HYDRANT CONDITION CONSULTATION WITH PLANNING AUTHORITY

Planning Ref: WA/58/21/PL

Address: Brookview Nursery Eastergate Lane Walberton BN18 0BA

Description: The removal of outdoor storage, including caravan & polytunnels, the erection of 7 workshop units comprising of 12 offices & 3 commercial units, associated parking, drainage and turning spaces. This application is in CIL Zone 3 (Zero Rated) as other development.

Proposed Block Plan
Scale 1:500

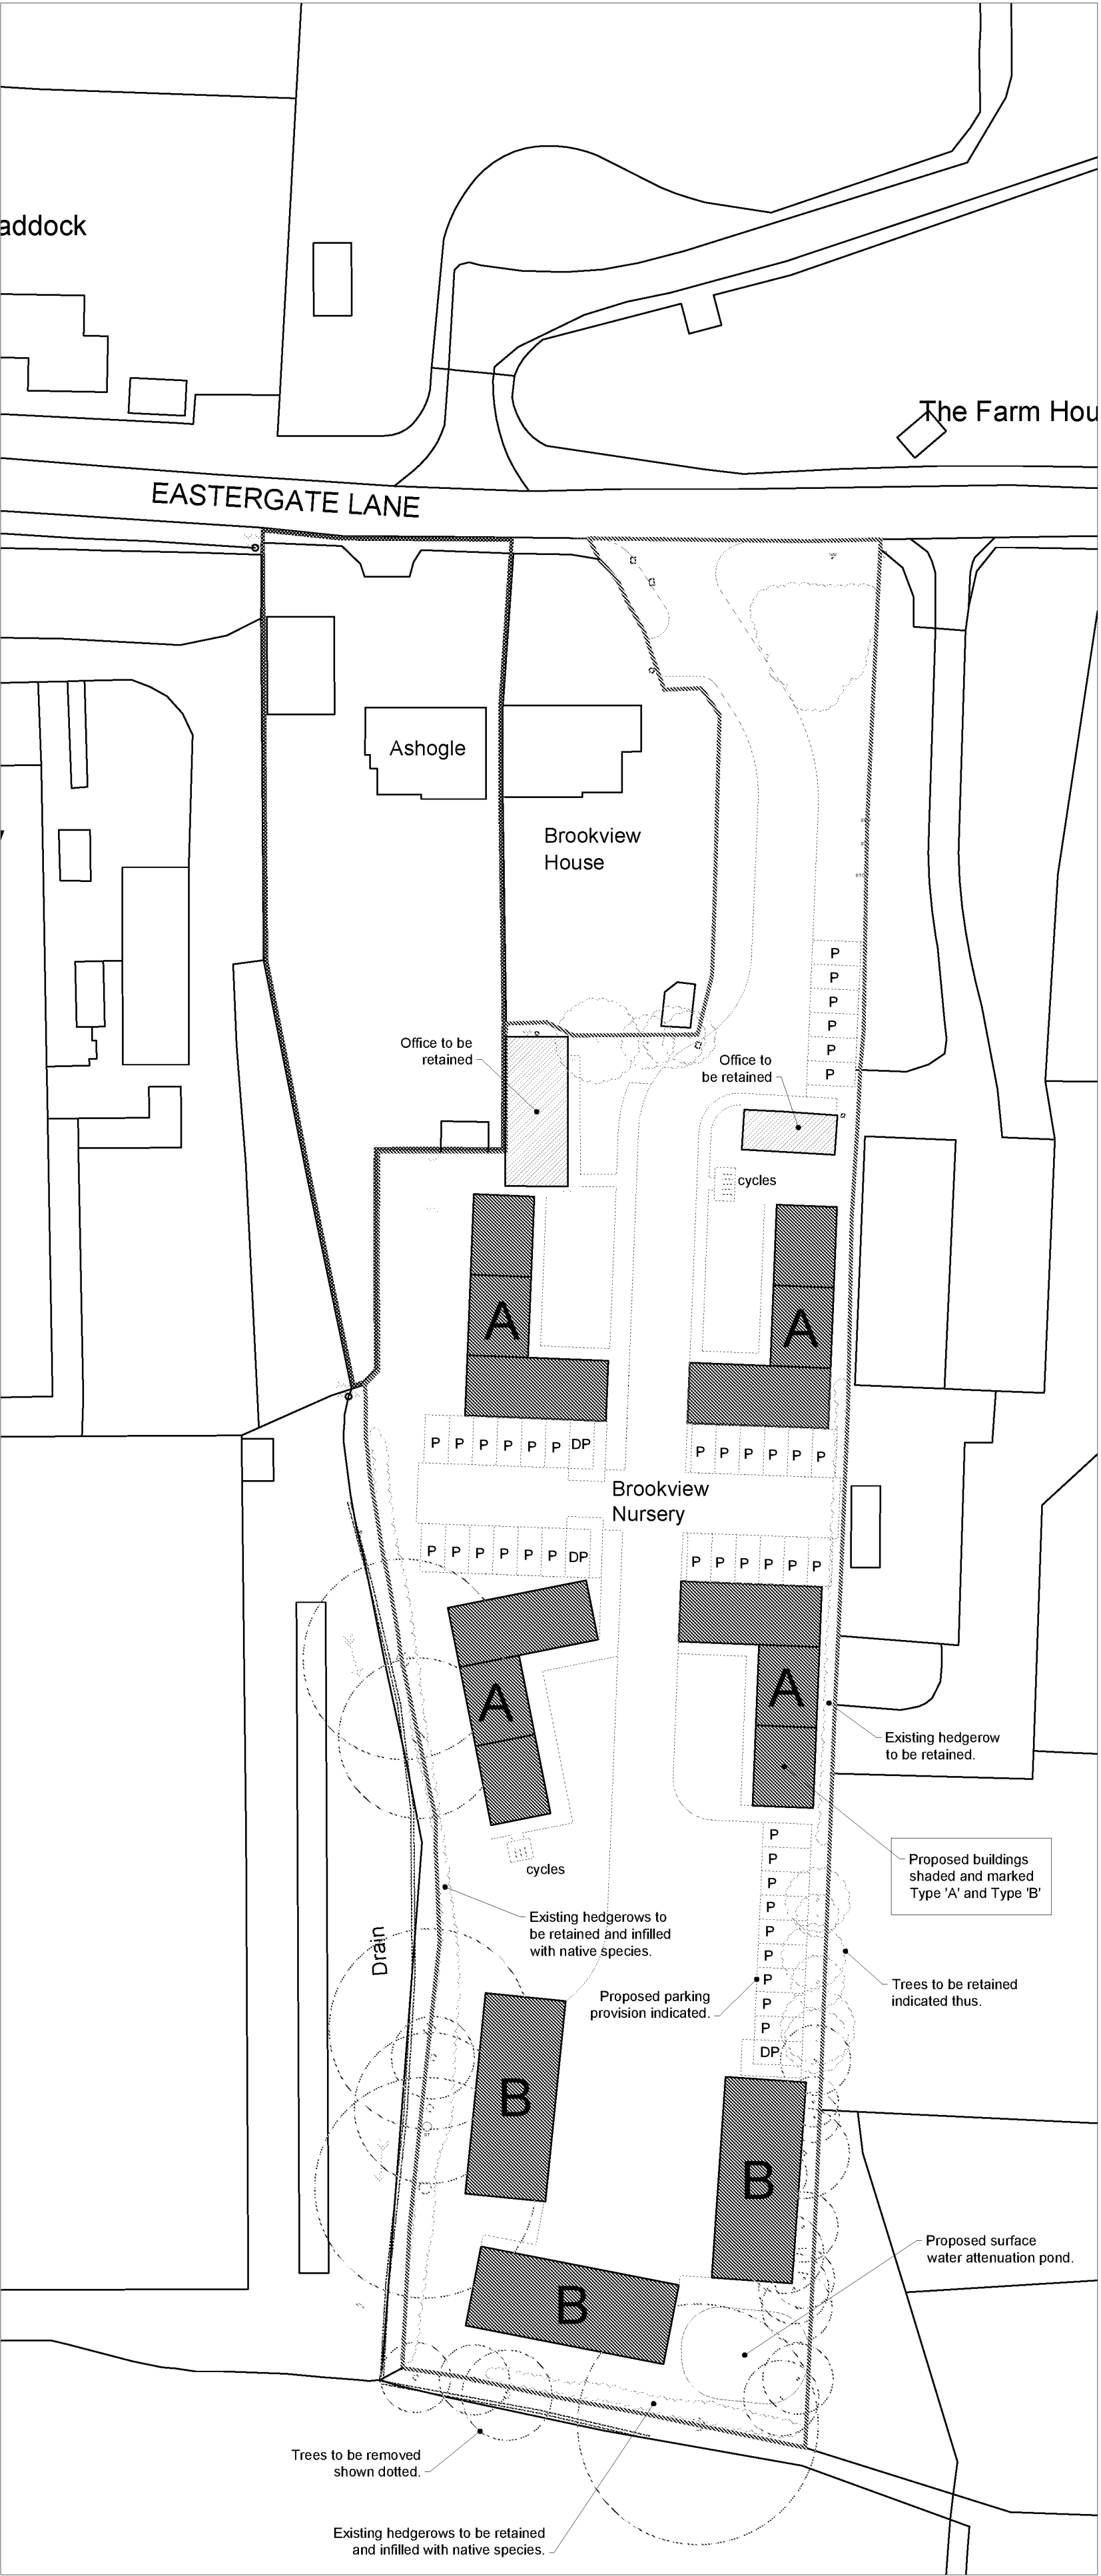
Please find attached a planning condition for application no. WA/58/21/PL for the requirement of an additional fire hydrant. Currently the nearest Hydrant to these proposed properties is 220 metres away. The supply of water for firefighting for a commercial premises should be within 90 metres.

Evidence will also be required that Fire Service vehicle access meets with the requirements identified in Approved Document B Volume 1 2019 Edition: B5 Section 13, including Table 13.1 and diagram 13.1, including a suitable turning area to enable a fire appliance to turn and make an exit, the appliance should not need to reverse more than 20 metres.

- 1) Prior to the commencement of the development details showing the proposed location of [1] one fire hydrant or stored water supply (in accordance with the West Sussex Fire and Rescue Guidance Notes) shall be submitted to and approved in writing by the Local Planning Authority in consultation with West Sussex County Council's Fire and Rescue Service. These approvals shall not be unreasonably withheld or delayed.
- 2) Prior to the first occupation of any dwelling/unit forming part of the proposed development that they will at their own expense install the fire hydrant (or in a phased programme if a large development) in the approved location to BS 750 standards or stored water supply and arrange for their connection to a water supply which is appropriate in terms of both pressure and volume for the purposes of firefighting.
